Your Ref:
Our Ref: FG/153/10/
Please ask for:
Mr J Smith

24th November 2010

Application for a 12.8m skip to remain on property driveway & installation of 1 large
hardwood, Iroko finish bi-folding gate to close off driveway
52-56 Ferring Street Ferring

GROUND FLOOR PLAN 1:100 Existing

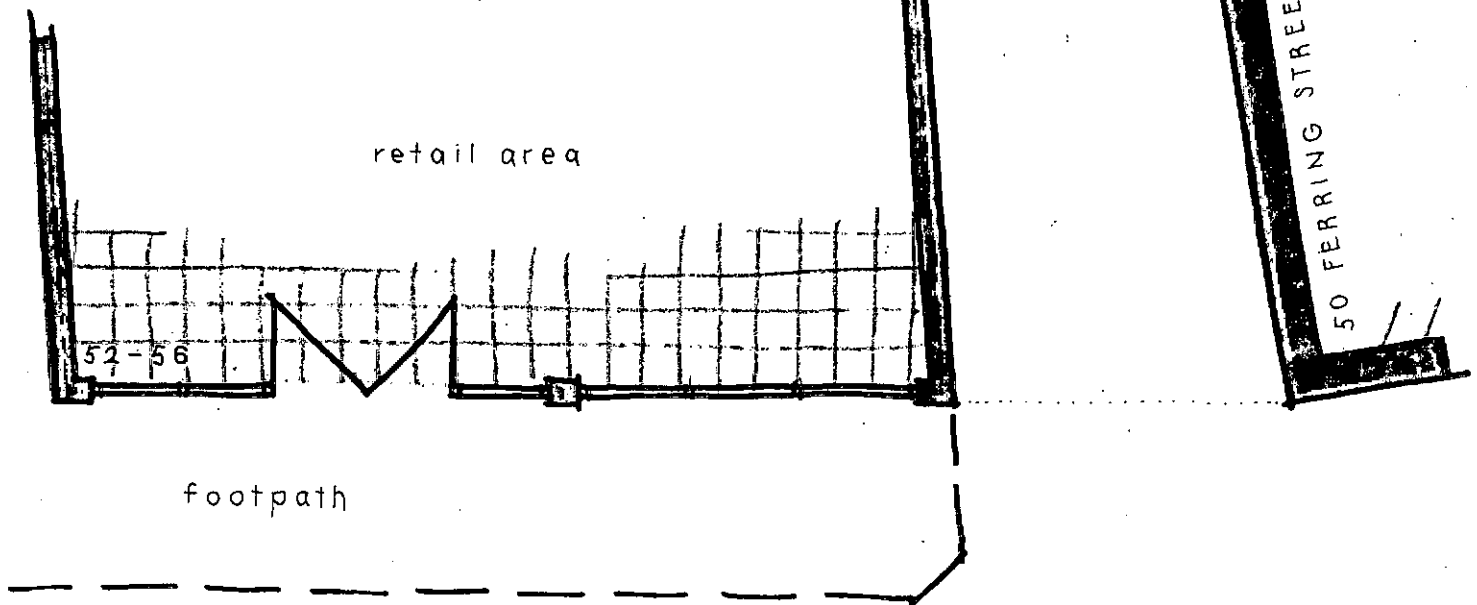
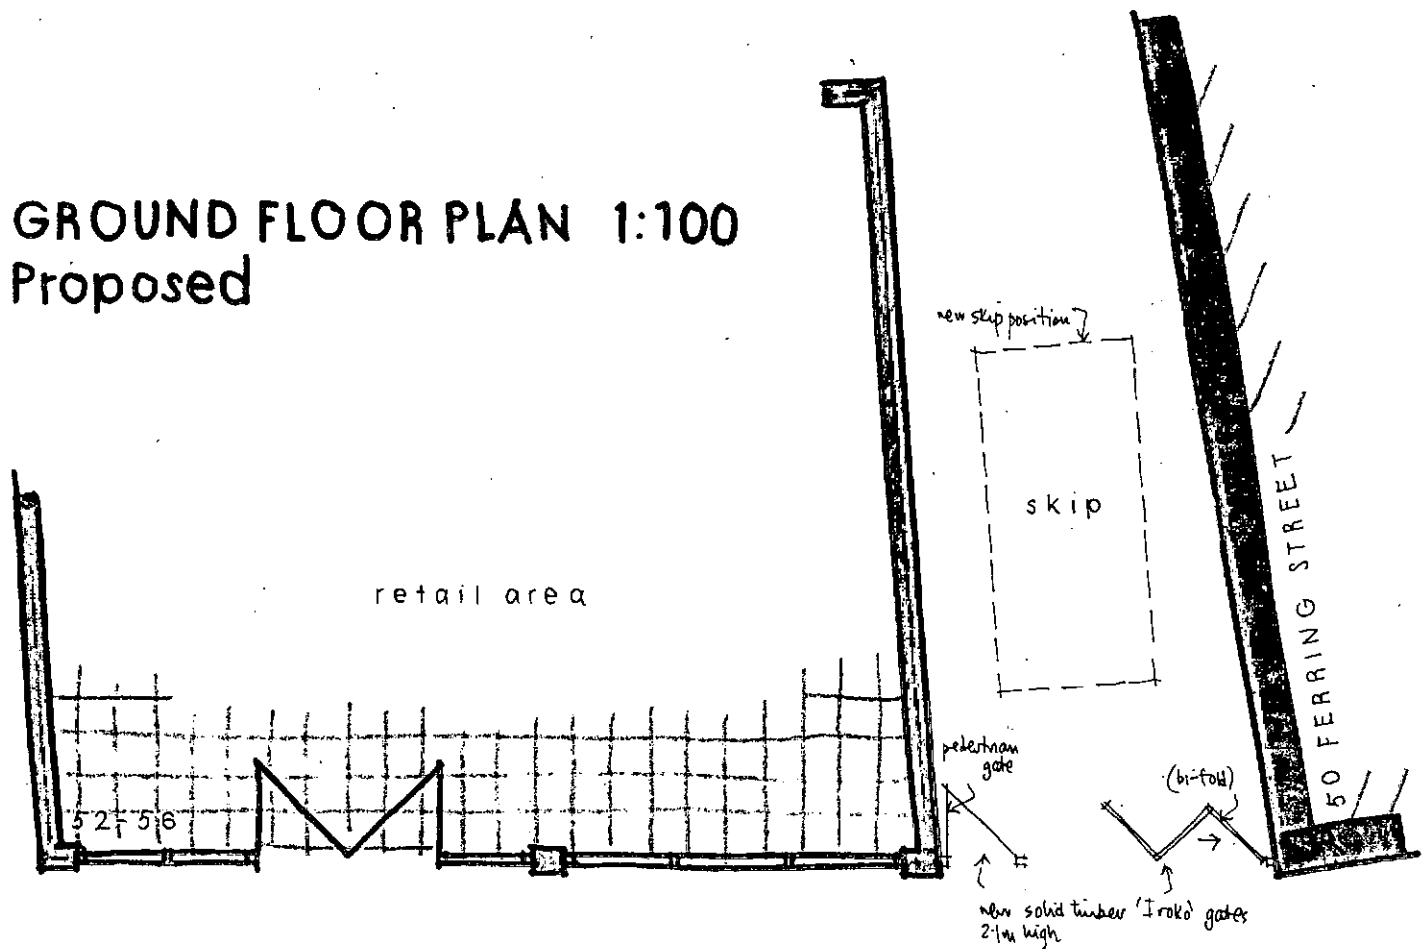
The installation of a gate would only serve to hide the skip and then of course only if kept closed. This is a distraction to the main issue which is whether a skip should be kept on this driveway in the first place as this would appear to be in contravention of the original planning approval which permitted the provision of a parking space for one vehicle
